RIBCHESTER PARISH COUNCIL

6 July 2021

Re: Planning Application 3/2021/0595 – Land at Preston Road, Ribchester, PR3 3XL – Change of Use of Land and erection of building for heliculture.

Flood Zones Map:
PENDLE VIEW, PRESTON ROAD,
RIBCHESTER, PR3 3XL

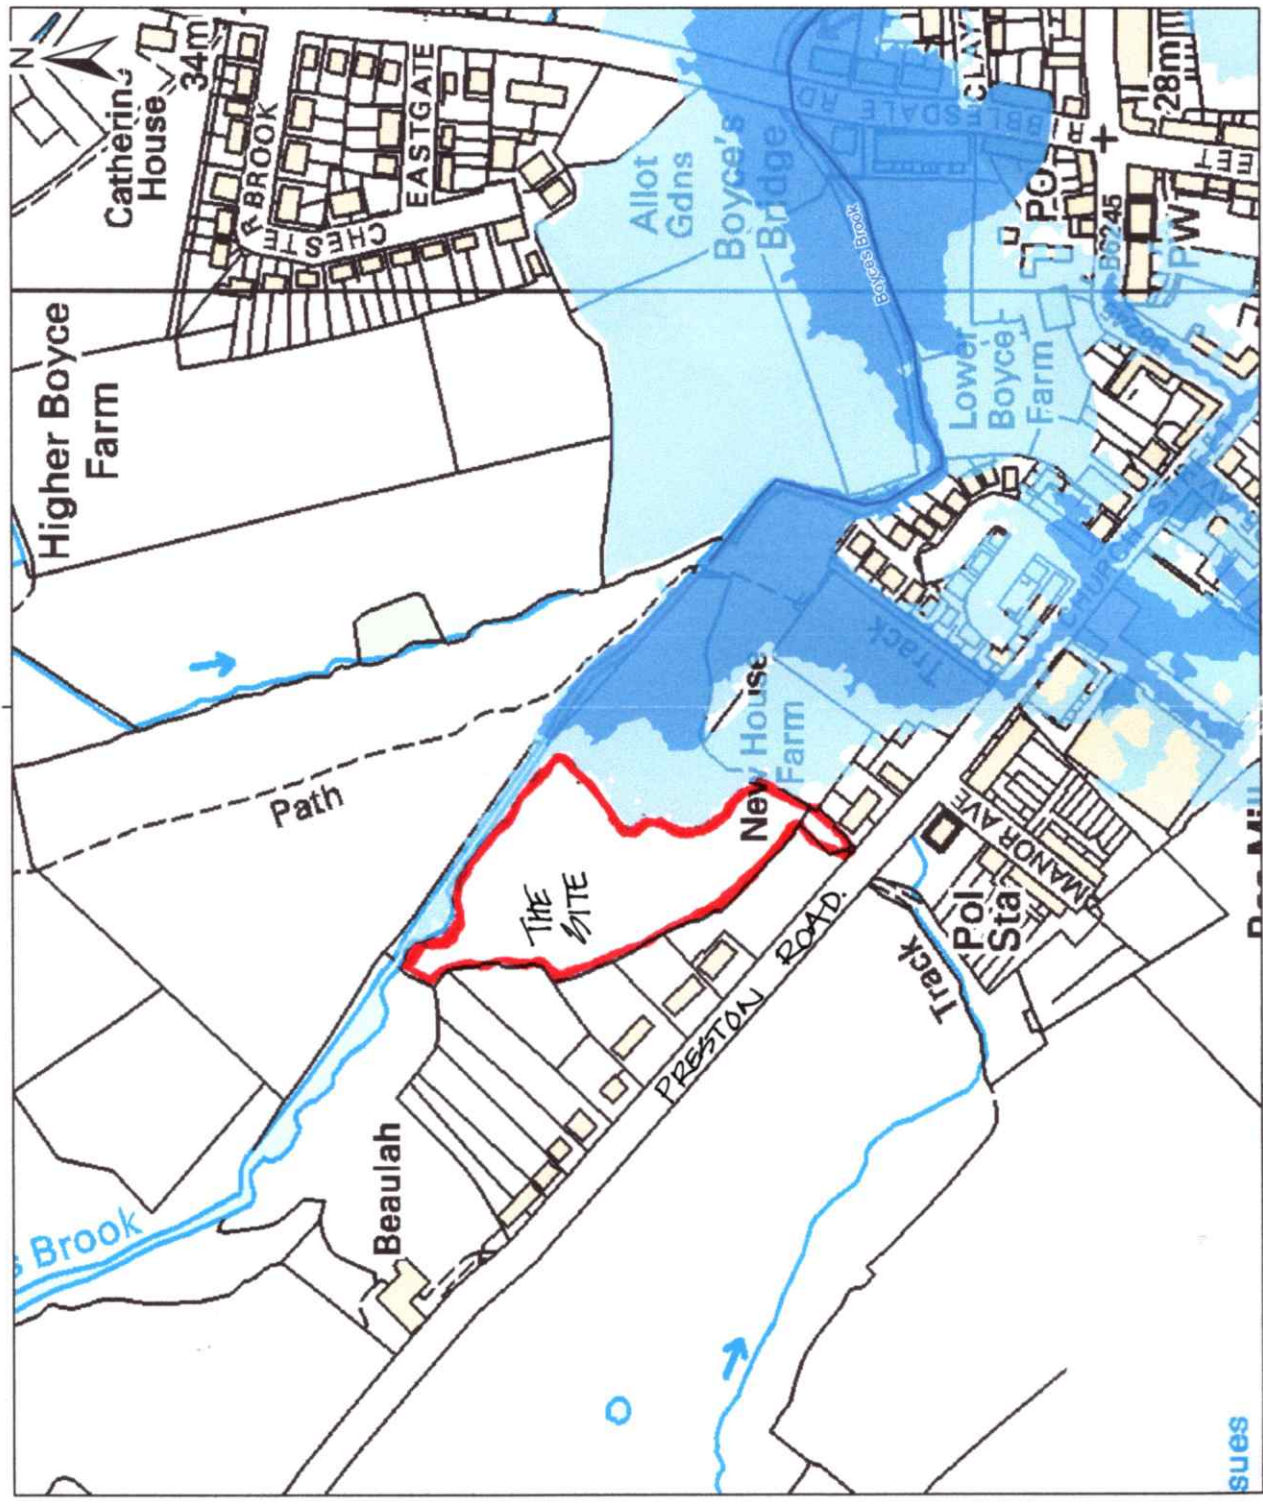
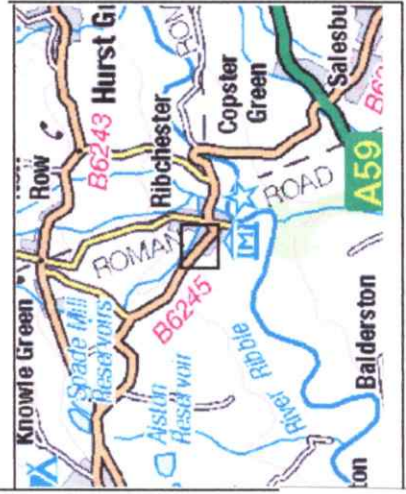
The Council does not agree that a resubmission which simply highlights (with over-typing on a map) that 'This is not in the Flood Zone' has demonstrated that there is any understanding of the lived experience or the concerns of the residents of Ribchester who regularly face the effects of flash flooding during heavy rainfall. This type of flooding is an increasingly regular occurrence in Ribchester, and advice from the Environment Agency confirms that given the changes to the climate, this will continue to be problematic for years to come.

The map provided shows that the revised position of the development will be in Flood Zone 1. The main benefit of this for the applicant is that he is not required to provide a flood risk

assessment. I submit that this does not abrogate his responsibility to demonstrate that there has been a full assessment of the outcome of building on an existing field (which will naturally absorb water during heavy rain). The supporting evidence that *the run-off from the site will be no greater than the greenfield run-off rate* does not appear to be provided. This would be essential for the responsible consideration of the application by this Council.
